Recommendation Report for Planning Permission for Works or Extension to a Dwelling

REF NO: EP/137/20/HH

LOCATION: Outspan
South Strand
East Preston
BN16 1PN

PROPOSAL: Construction of garage/storage building.

Plan (1:50)

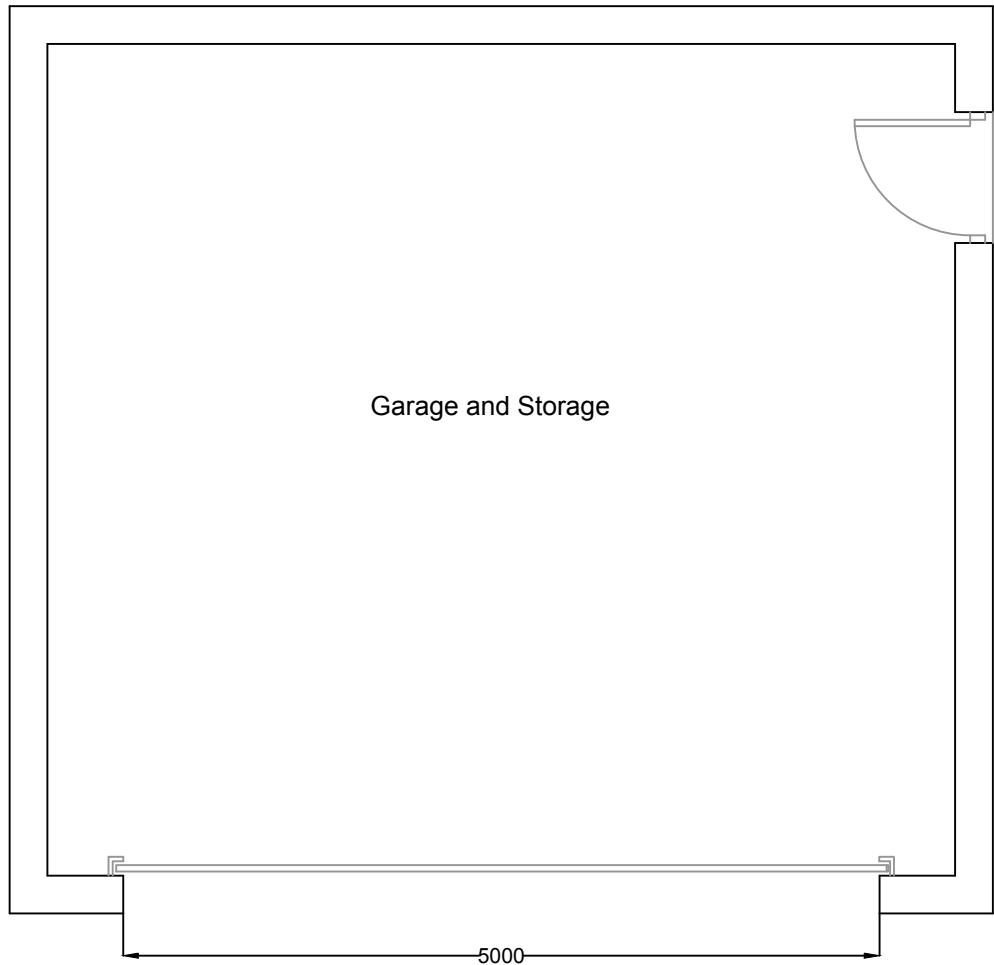
The proposed garage is sited to the Eastern elevation of the host dwelling, and as such, directly abuts Club Walk. As a result of this siting, there will be views of the proposal from within the public realm and as such, a change in appearance of the application site. However, this alone does not prescribe refusal of the application as it has to be established that the proposal would result in harm to the character of the host dwelling, or to its locality. In this instance, whilst the prominent siting of the garage is noted it is not considered to result in any detrimental harmful impact upon the character of the host dwelling, or its locality. This is predominantly due to the mixed character of Club Walk and the established precedent of built form along this road, and within the application site. There are examples of garages and sheds along the road, whether forward of the front elevation of the host dwelling, or the entirely detached garage block at the South side of the road. Furthermore, the properties that front Club Walk predominantly utilise front boundary fencing in this location. Therefore, it would not be considered to be a significant change to the character of the movement along Club Walk, in that the frontage would remain as a solid frontage.

The proposed development is considered to represent accordance with T SP1 of the Arun Local Plan. This is as it creates capacity for on-site parking within the application site. Furthermore, it is noted that concerns have been raised with relation for potential impact upon pedestrian safety. However, upon assessment, the proposal is not considered to result in any detrimental impact upon the safety of

pedestrians on Club Walk. This is due to the nature of the road itself, as it does not have high numbers of vehicle movements and the low vehicle speeds along the road.

As such, the proposed development is considered to be in accordance with T SP1 of the Arun Local Plan.

East Elevation

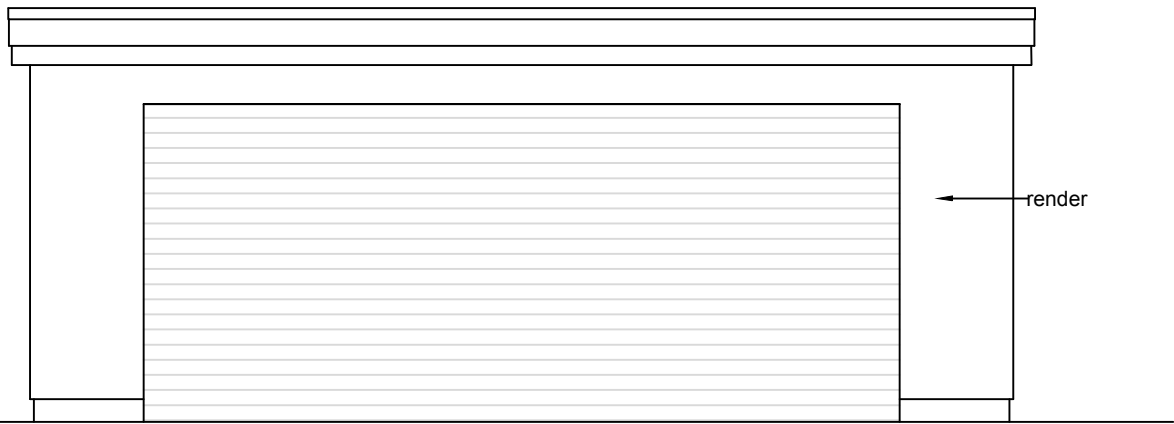
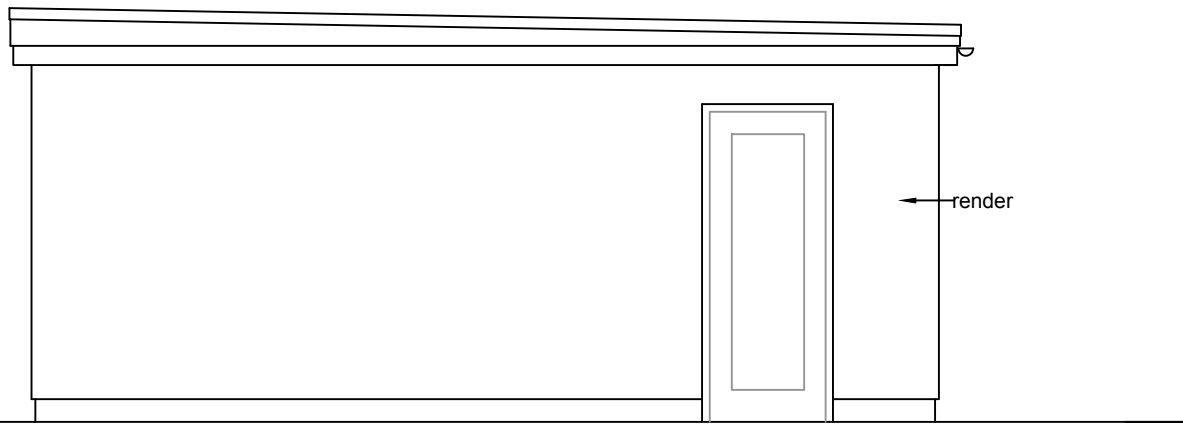
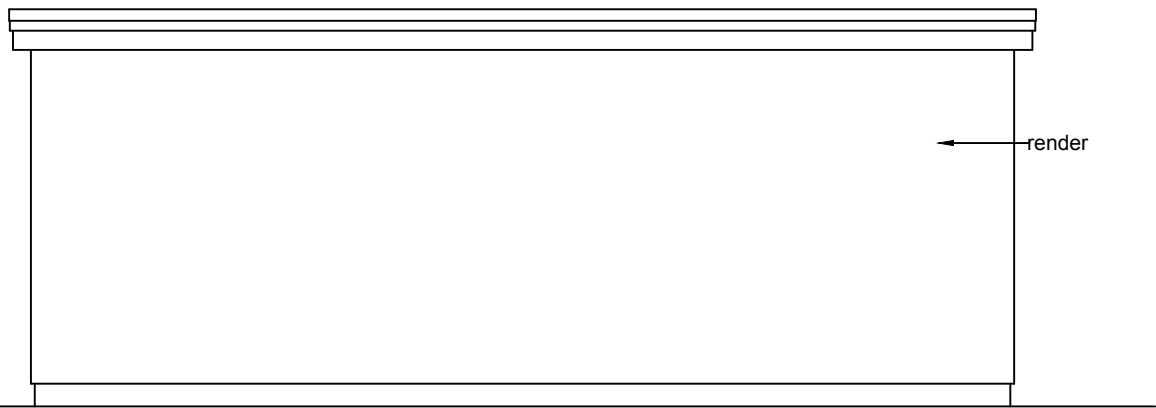
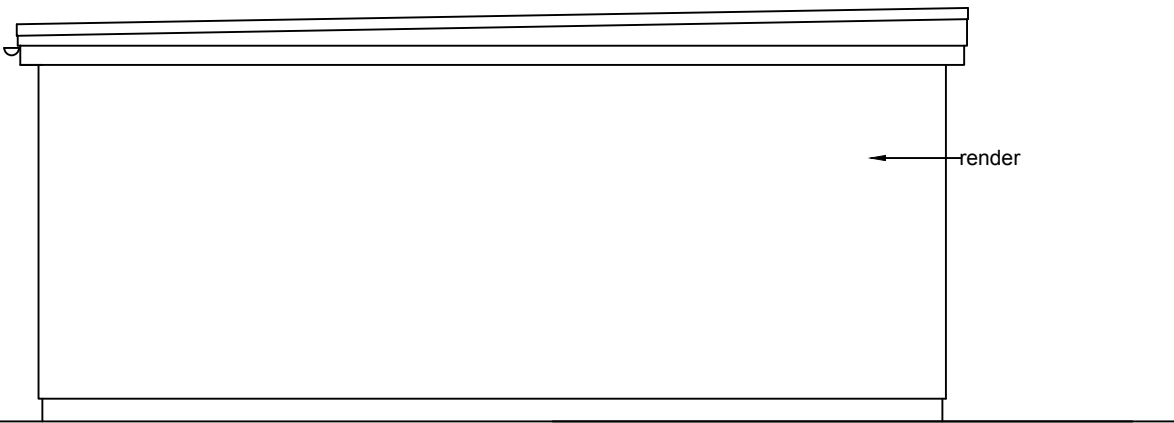
- The mass and scale of the proposal are out of keeping with the host dwelling and its locality.
- Reversing in and out of the garage may be dangerous for pedestrian safety.

The proposed development is not considered to result in any harmful overbearing or overshadowing impact upon the occupiers of neighbouring dwellings. The proposal has a maximum height of 2.7m high, and is sited approximately 2.6m from the Northern boundary of the application site which is considered to be an acceptable distance in order to prevent any significantly harmful overbearing or overshadowing impact. To the South, there is an access path which creates a separation distance, which is significant enough to alleviate any potential for harm to the occupier of this neighbouring dwelling. The proposal is not considered to result in any impact upon loss of privacy to neighbouring occupiers, due to its single storey nature. The proposed development is considered to be in accordance with D DM1(3) and D DM4(c) of the Arun Local Plan.

The proposed development is considered to be in accordance with D DM1 of the Arun Local Plan.
